From: Bloomer, David <David.Bloomer@lancashire.gov.uk>
Sent: 11 August 2015 12:50
To: Colin Sharpe
Cc: LHS Customer Service; planning
Subject: app3/2015/0462 land to rear 19 - 21 King Street Whalley

Dave Bloomer
Highways Development Control
Lancashire County Council

GROUND FLOOR PLAN

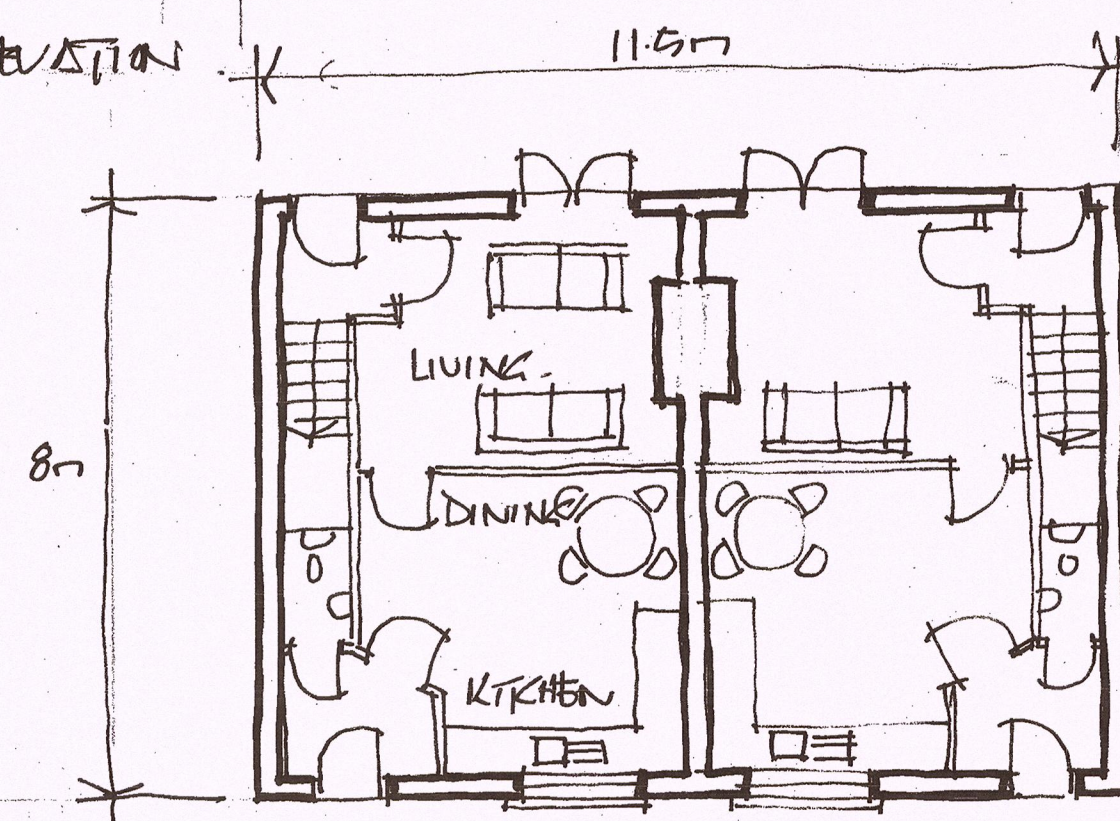
Whilst I would raise no objection to the proposal in principle there are a number of issues I would like to raise in respect of this application. The vehicular access off King Street is narrow and unadopted. This street has no turning facilities and any deliveries etc to the proposed properties would have to reverse along the back street which should not be encouraged. I would therefore suggest that the 2 visitor parking spaces be deleted and this area converted into a turning head with appropriate signage prohibiting parking.

2 The layout of the development shall include provisions to enable vehicles to enter and leave the highway in forward gear and such provisions shall be laid out in accordance with the approved plan and the vehicular turning space shall be laid out and be available for use before the development is brought into use and maintained thereafter. Reason: Vehicles reversing to and from the highway are a hazard to other road users.
